Case Officer: Sarah Greenall**Recommendation:** Approve**Applicant:** Mr Jason Williams**Proposal:** Discharge of condition 3 (external windows and doors) of 19/01006/LB**Expiry Date:** 23 October 2019

- 2.1. The current application seeks to discharge Condition 3 (external windows and doors) of 19/01006/LB which was granted permission on 8th August 2019.

5 Typical Window Head, Cill & Glazing Bar Detail
 Scale: 1:5

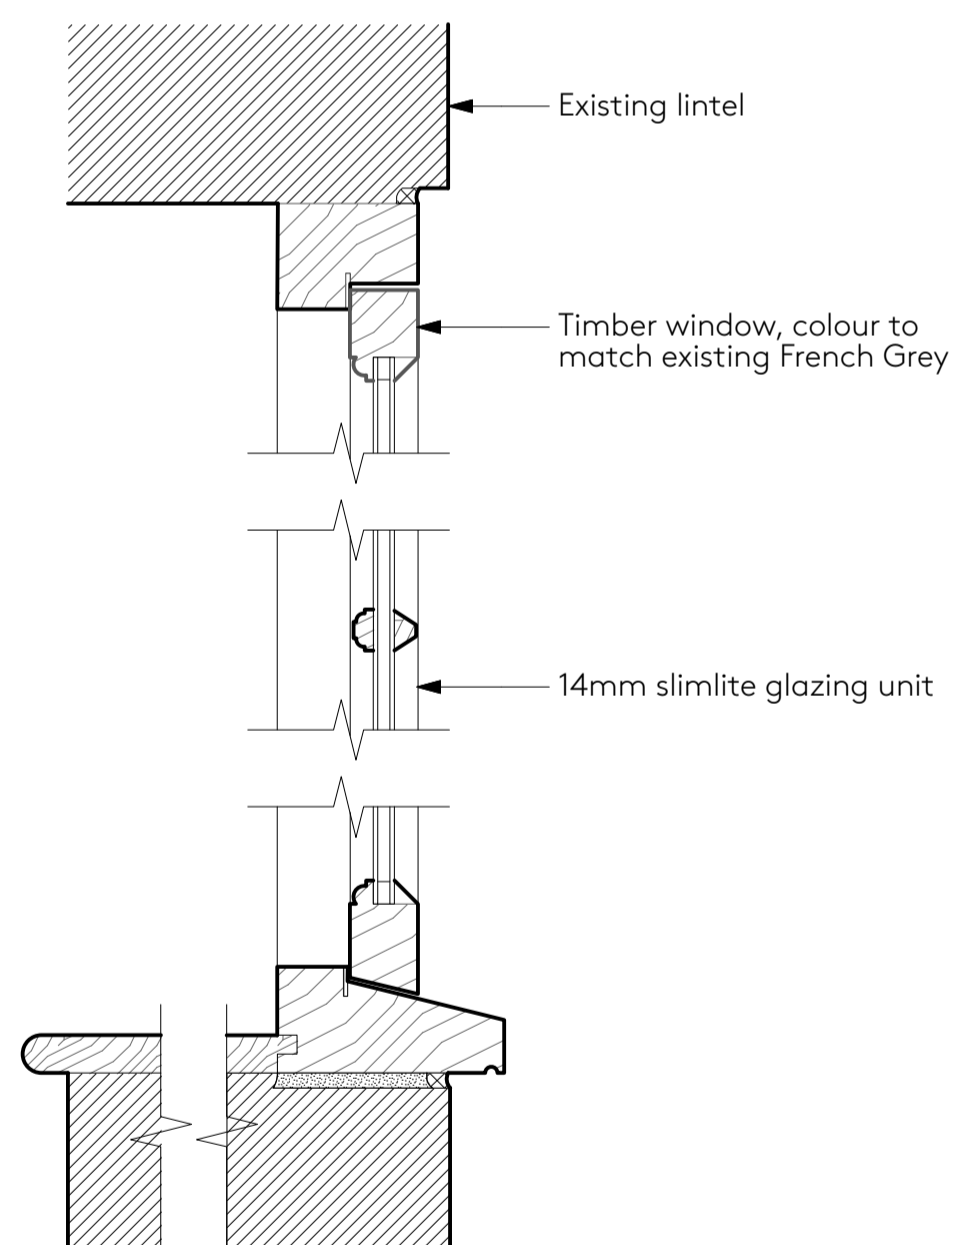
- 6.2. CONSERVATION (CDC): **No objections** providing a true glazing bar is used for the windows and not a stick-on glazing bar.

- 8.1. Condition 3 required that full joinery details of the windows and doors should be submitted to and approved by the Local Planning Authority prior to the commencement of the development. The Conservation Officer initially raised concern over the fact the window detail appeared to show a stuck-on glazing bar which would not be suitable for a listed building. However, the applicant clarified that a true glazing bar would be used with individual panes of glass and additional plans were submitted to reflect this. The window and door details are therefore considered to be acceptable.

Condition 3 – Windows/doors in accordance with drawings 1, 2, 3 and for shown on drawing No. P11, glazing bar plan submitted via email on 02.10.2019 and Glazing bar detail – Elm Tree House submitted via email on 22.10.2019.
